Online Comment

Application H05-0664-21
Location Land to East of Holbeach Manor Fleet Road PE12 7AX
Proposal Residential development comprising 5 detached dwellings off private drive including retaining and converting existing water tower

Name Ian Marshman, Historic Environment Officer
Address Lincolnshire County Council Lancaster House 36 Orchard Street LN1 1XX

Date Submitted 16-07-21
For/Against Comments

PLOT 3 - FLOOR LAYOUTS

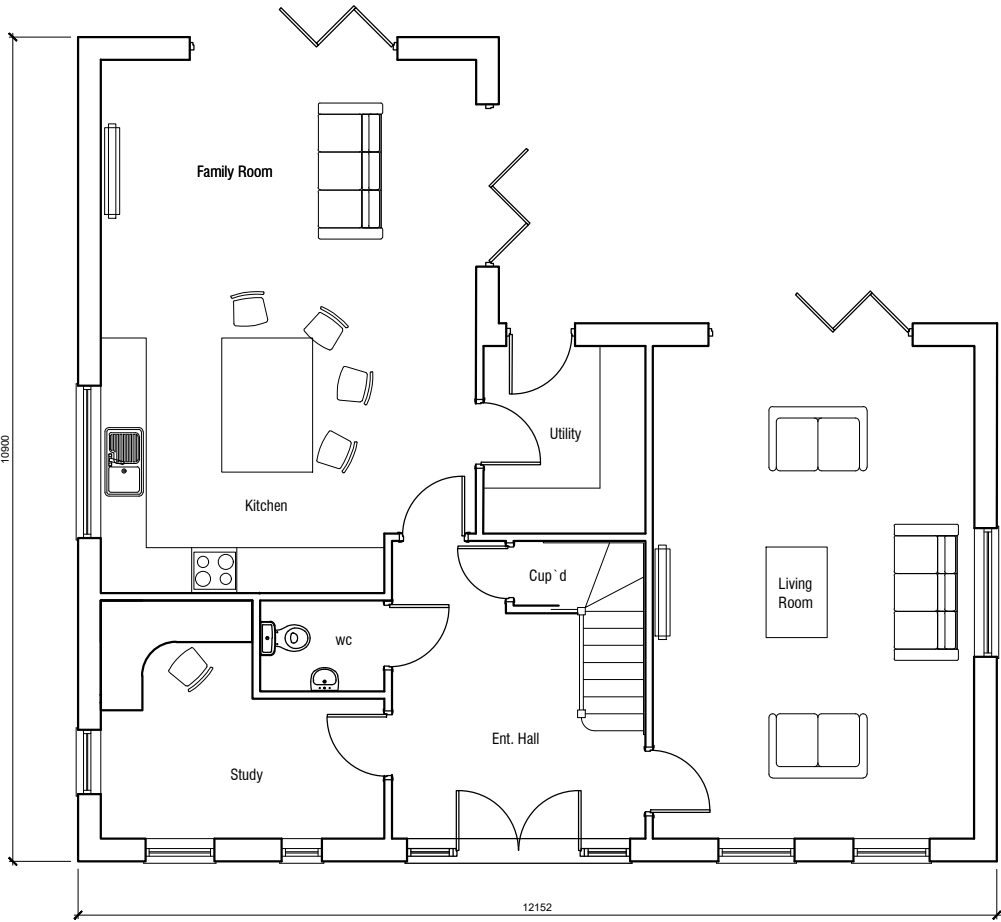
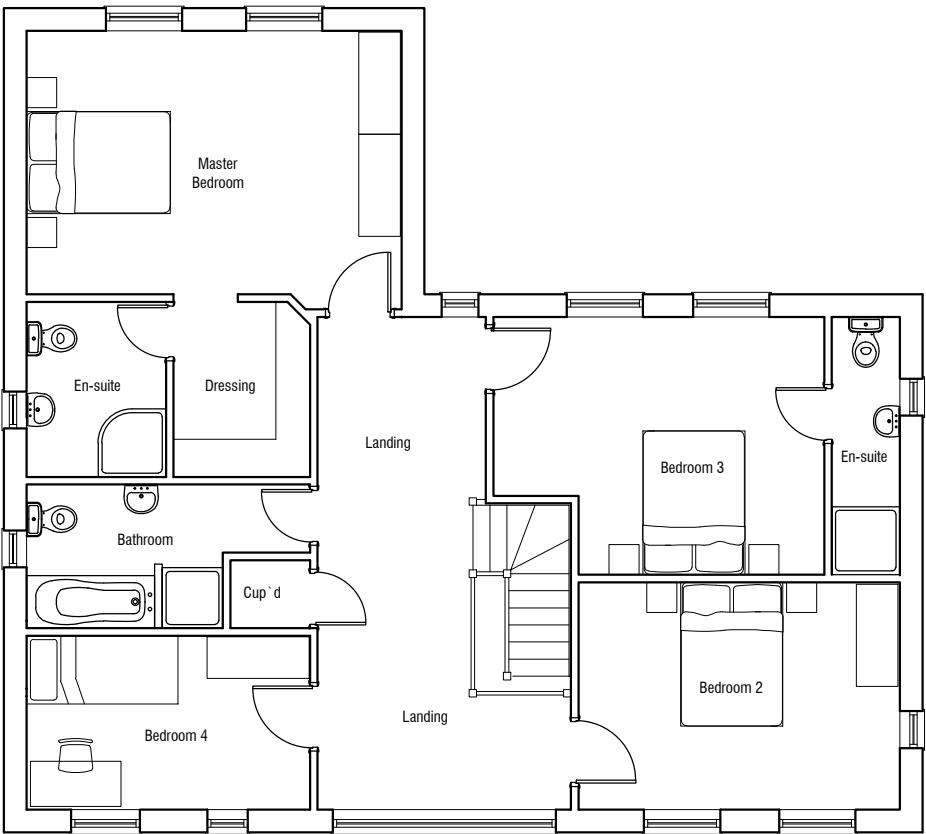
The Water Tower can be considered a non-designated heritage asset in the terminology of the National Planning Policy Framework, the significance of which merits consideration in any future planning decision.

It is recommended that prior to the conversion of the water tower a photographic record of it should be made to preserve by record any evidence for its original design, development and function. This should be submitted to and approved in writing by the local planning authority prior to development/conversion taking place.
